3rd February 2010

The Town and Country Planning Act 1990 (as amended)

Replacement dwelling (Departure from the Development Plan)
The Brickfield Hoe Lane Flansham

Title: Floor plan & Block plan

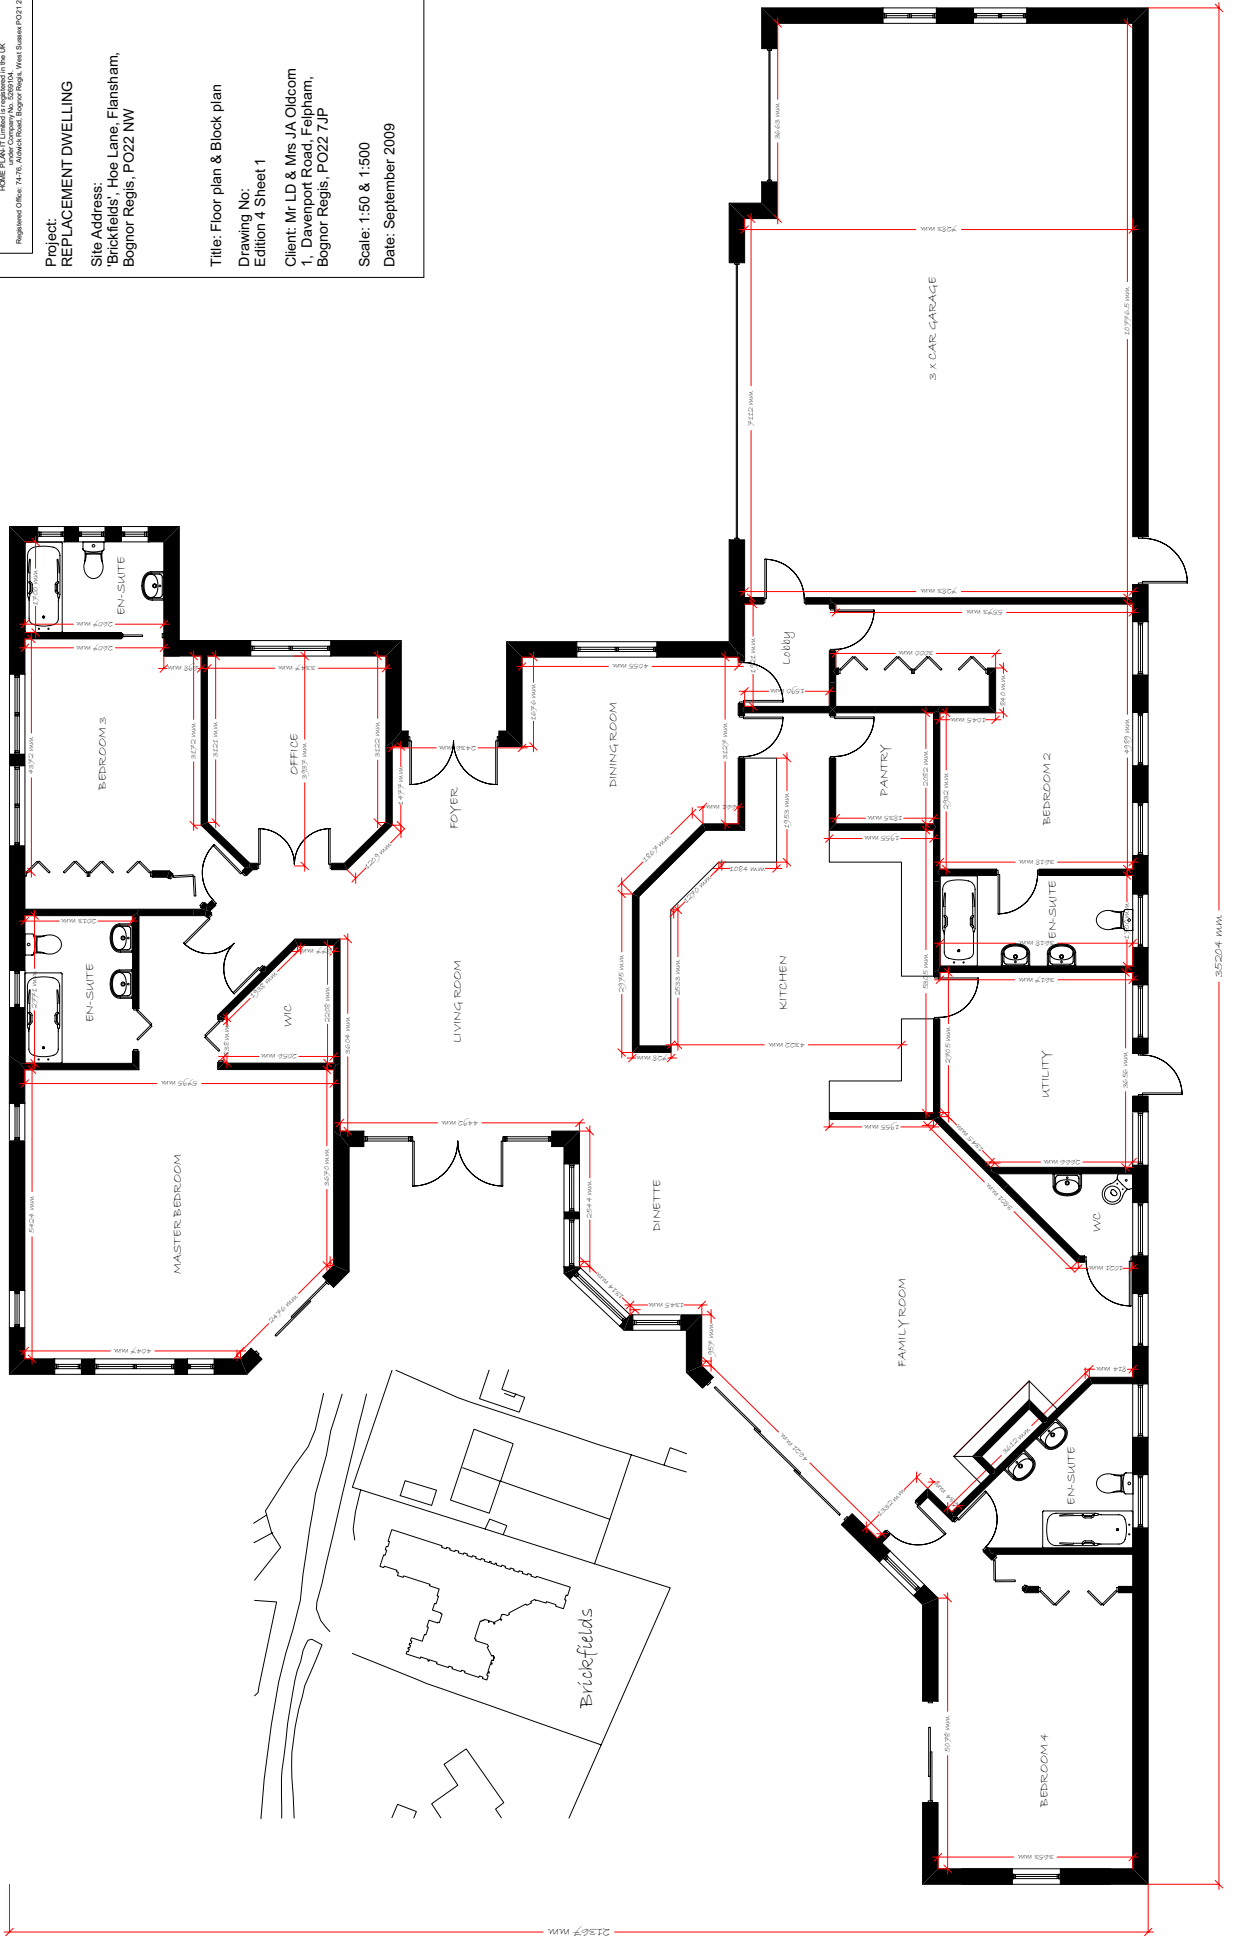
Whilst being impressed with the design, members of the Parish Council have concerns that the proposed dwelling will be larger than adjacent surrounding buildings and it may be considered unsightly because of the lengthy roof line. The Planning Officer will no doubt wish therefore to consider whether the proposal fits in with the character and appearance of the area. ☐
